THE ABLE MARINE ENERGY PARK DEVELOPMENT CONSENT ORDER

TR030001

Comments on Responses to the Second Round of Written Questions

Harbour Master, Humber

Figure 6 Model layout and bathymetry (with AMEP scheme) also showing locations of E.ON and Centrica intakes and outfalls

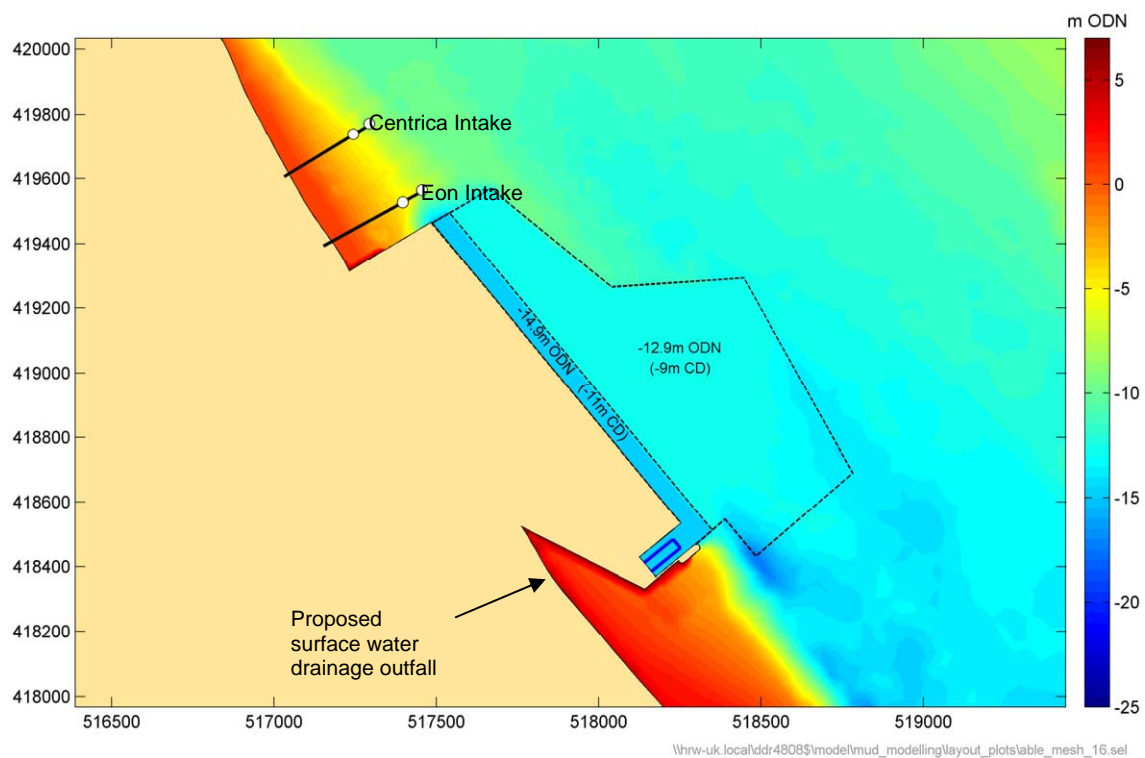
Able – Q. 51 – How does AMEP propose to deal with the predicted build up of silt at the outfall/intakes of Centrica and E.On in the long term?

3. The position of the Harbour Master, Humber throughout this examination, and as set out in his response to question 51 of the Second Round of Written Questions, has been that Able should be required to take appropriate steps to prevent or remediate impacts on its neighbours that have the potential to affect the efficient operation/navigation of the river and that such matters should be dealt with by means of protective provisions in the DCO or legally binding side agreements, completed before the Order is made.

4. Able's response does not deal with this point. Rather it addresses the nature of the risk (thought to be limited to the two outfalls, rather than to either of the intakes) and suggests that this could be managed by periodic "plough" dredging local to the outfalls if the structures remain at their present location or by a more permanent solution that would involve the diversion of both outfalls so that they discharge through the new quay. These proposals were discussed at the hearing on 13 September at which it became clear that Able's preference would be for passive provision only to be constructed within the quay.

5. The Harbour Master, Humber wishes to reserve his position on this matter until the MMO's considered opinion on Able's proposals is made known. In any event, however, he remains of the view that all necessary protection for these outfalls and intakes must be provided by way of express statutory obligation imposed on Able from the outset. This will ensure that necessary action is taken as and when it is needed, whilst leaving the parties free to agree other arrangements should they decide to do so.
